Jeffrey Peng
Department of Planning, Housing and Infrastructure
Major Projects Portal

State Environmental Planning Policy (Transport and Infrastructure) 2021
State Significant Development Application - SSD-63168959
269 Lane Cove Road, Macquarie Park
Request for additional information

9 September 2024

LANDSCAPE SITE MASTERPLAN

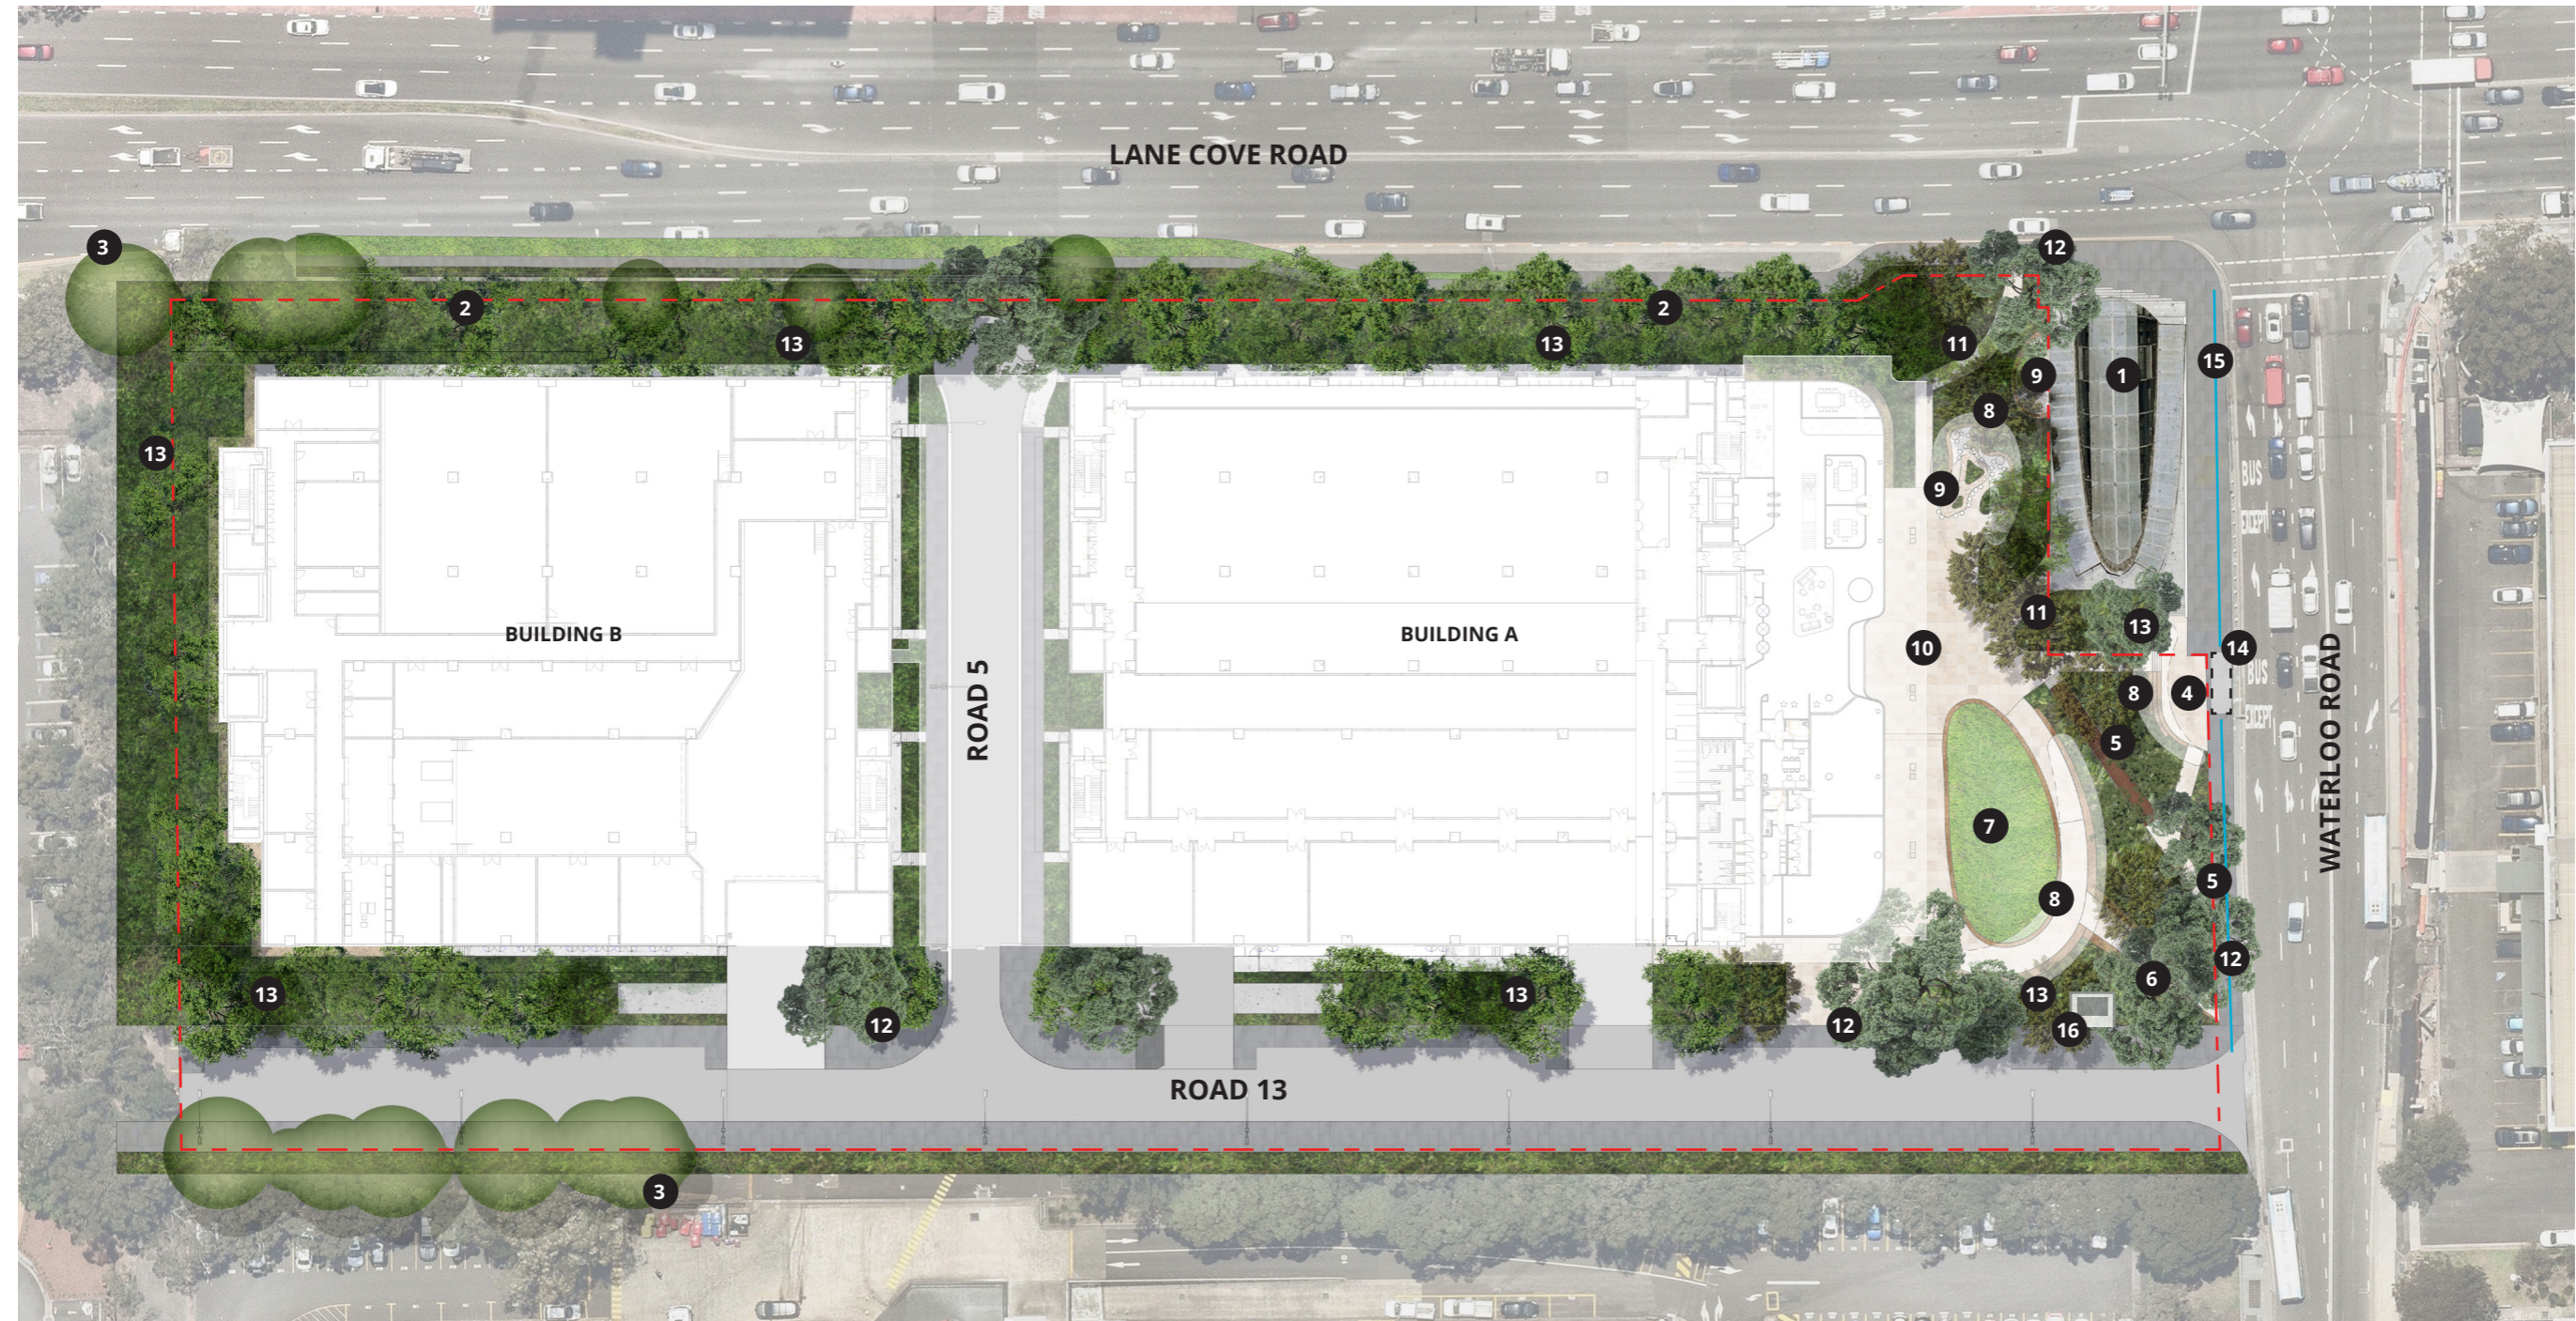
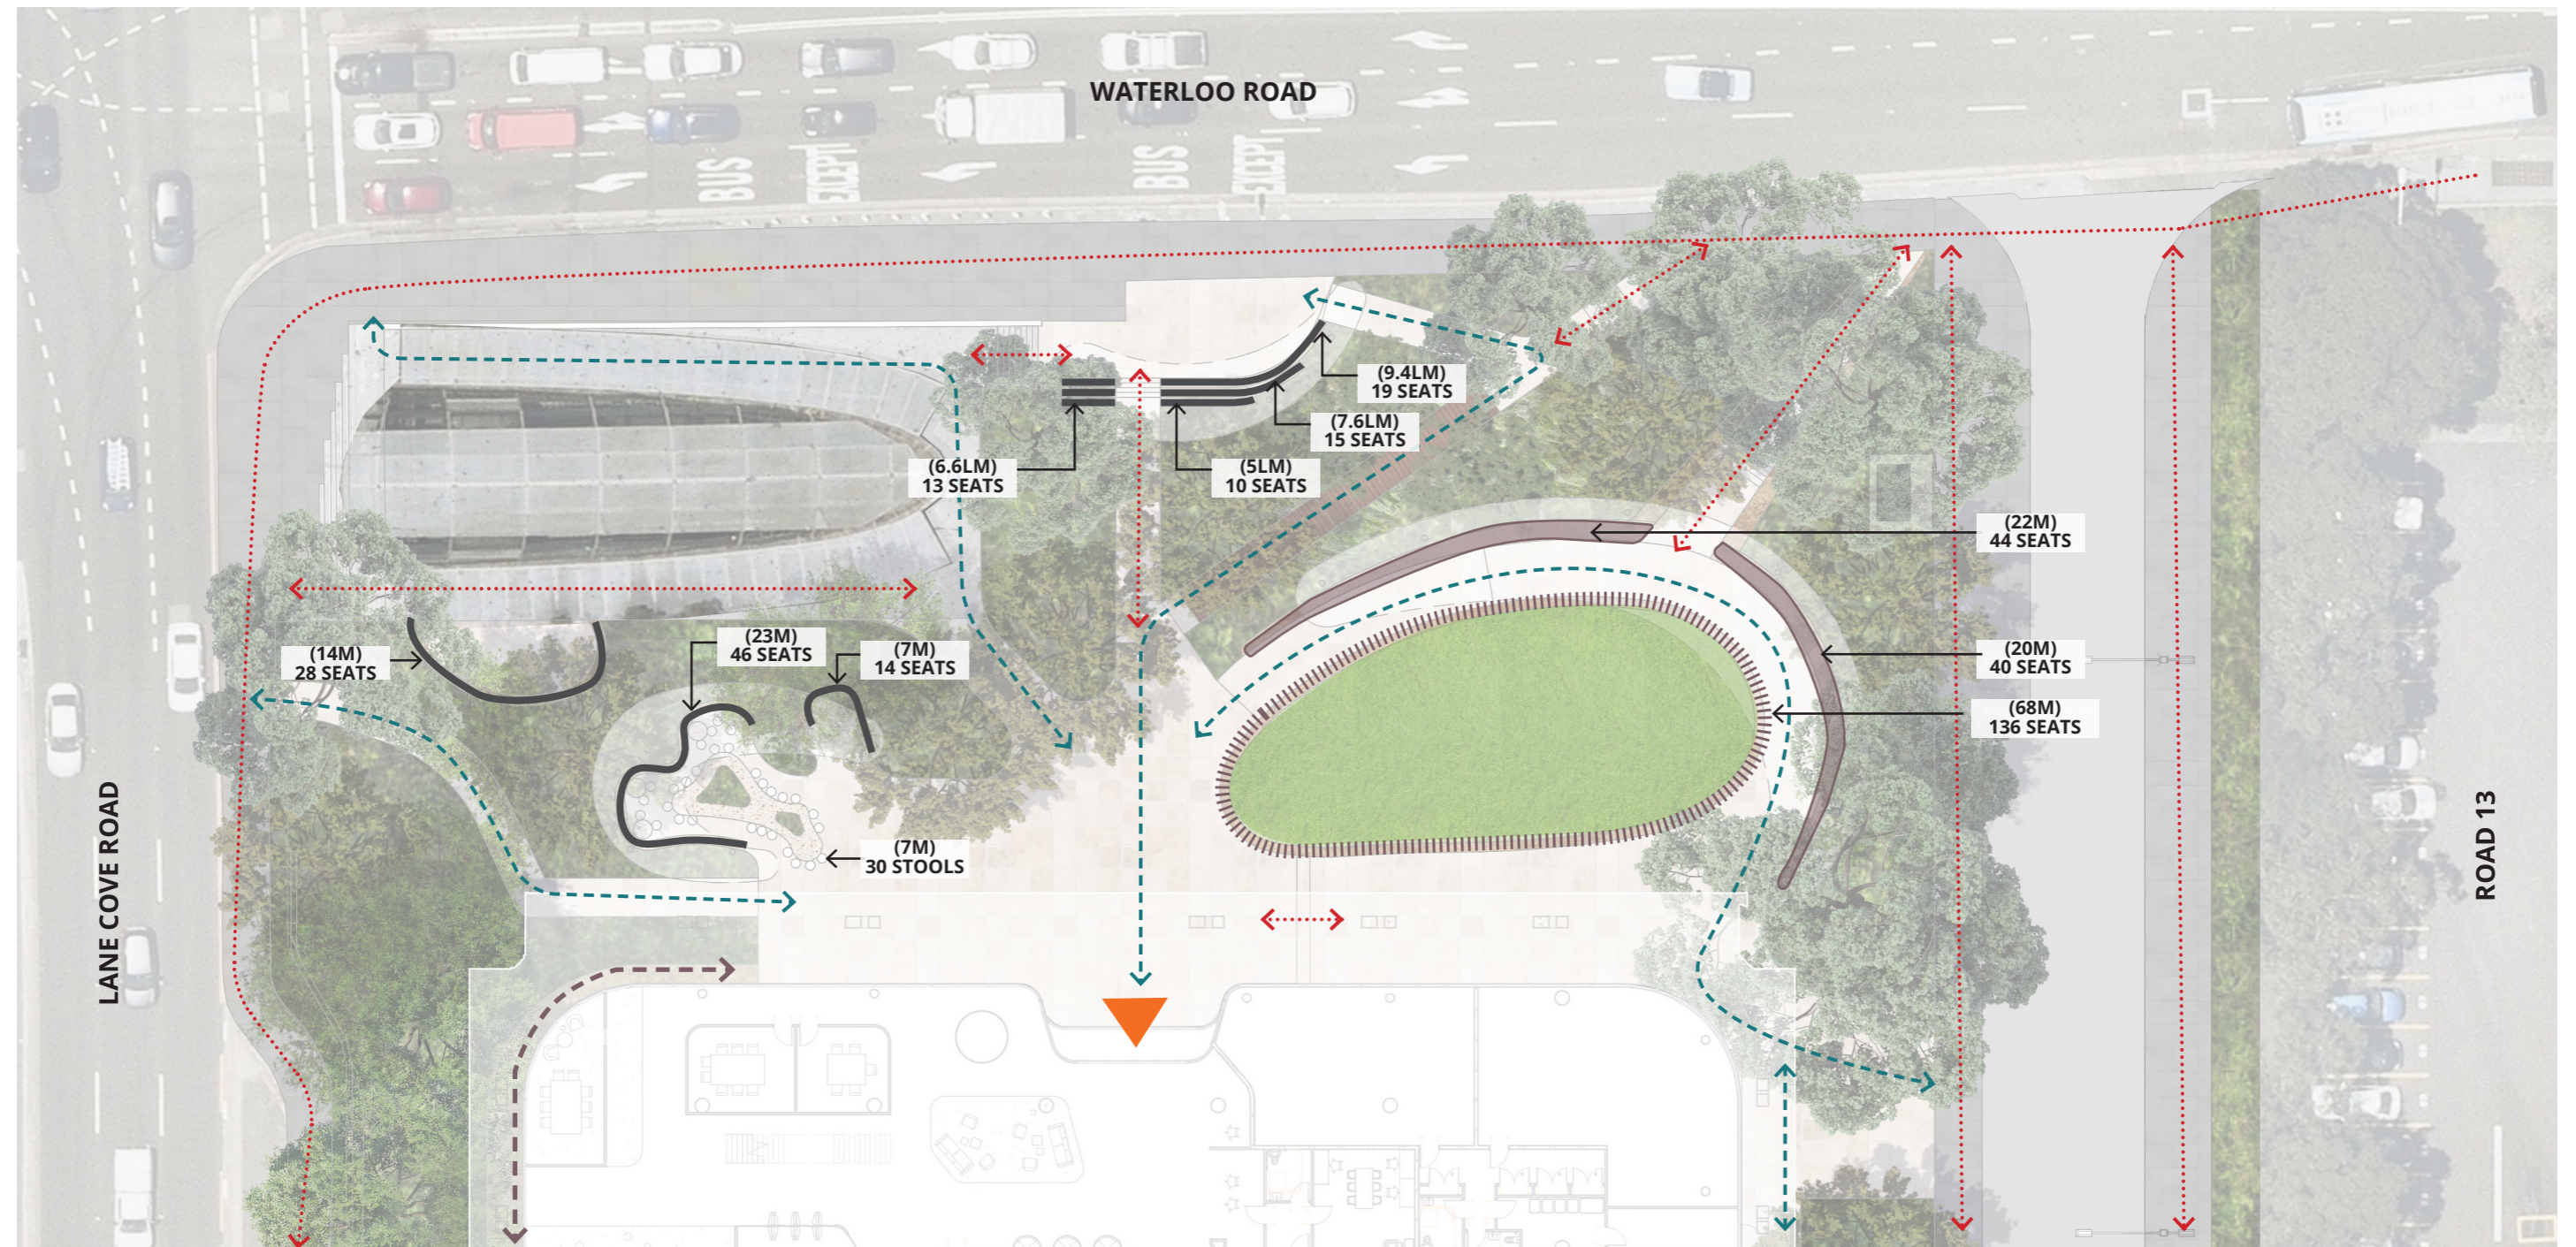
- j) Clarify if the extent of landscaping will be beyond the proposed site boundary and entering Sydney Metro's License Maintenance Area (LMA) land, shown in blue on the below extract. Should the proposed landscaping encroach Sydney Metro's LMA land, the Applicant must consult with Sydney Metro and its operator regarding maintenance and any other necessary processes.
